DEADLINE 7 RESPONSE
KENT DOWNS AONB RESPONSE TO
National Highways Deadline 6 Submission

**9.132 Post-event submissions, including written submission of oral
comments, for ISH9**

The Kent Downs AONB Unit raises the following points in response to the Applicant's submission:

*Local Landscape Character Area boundaries of the Kent Downs AONB LCA, West Kent Downs, Sub-areas Cobham and Shorne*

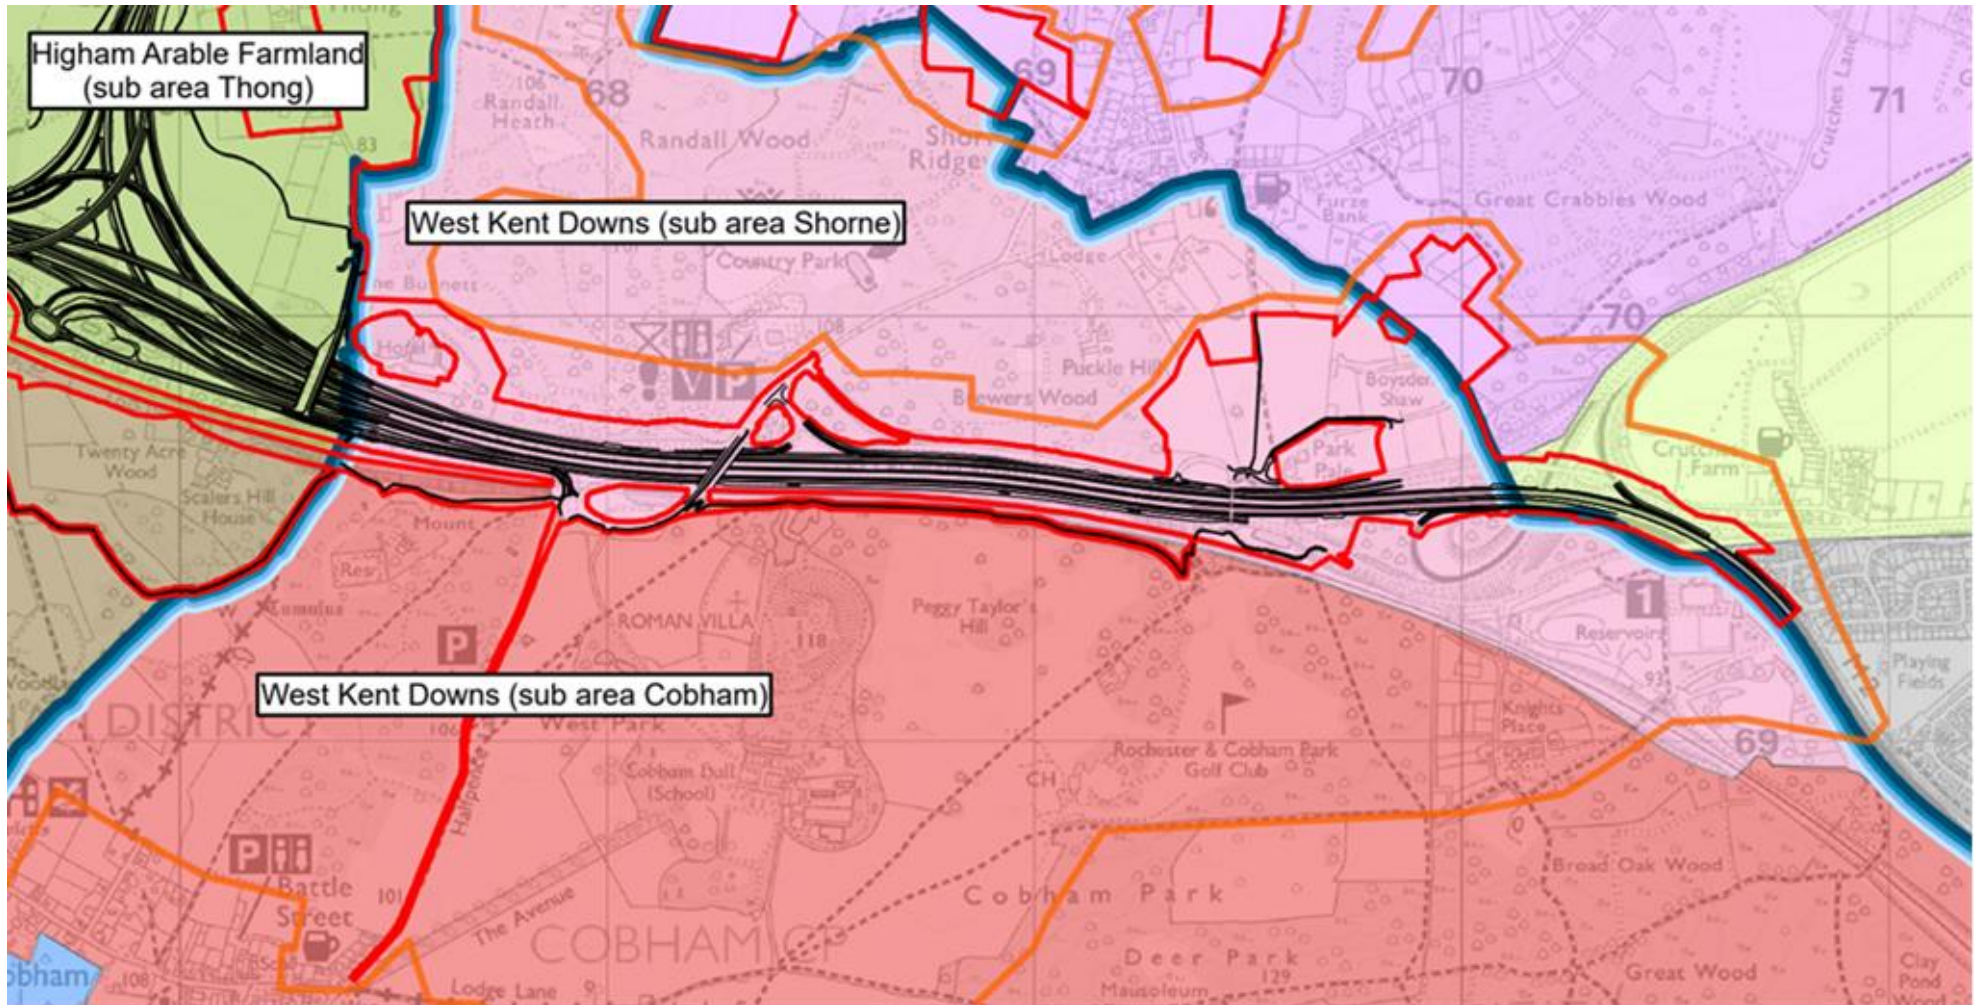
This response wholly fails to recognise or respond to the AONB Unit's concern that, notwithstanding requirements for key views to be retained and planting to be reflective of landscape character, the extent of woodland proposed here would fail to reflect, and indeed would largely remove, the existing retained localised historic 'parkland' landscape character as the features that characterise the land as such would be mainly subsumed within the proposed woodland planting. We note that elsewhere in the Scheme where there is historic parkland character this is sought to be retained, such as on land to the south of HS1 where it is advised in Table 3.3 Schedule of landscape effects on LLCAs during operation in 6.3 Environmental Statement - Appendix 7.9 (APP-384 [link](#)), 'A key consideration for proposed planting mitigation has been to reflect the parkland character of this LLCA, using scattered tree planting to reinstate trees removed during construction.'
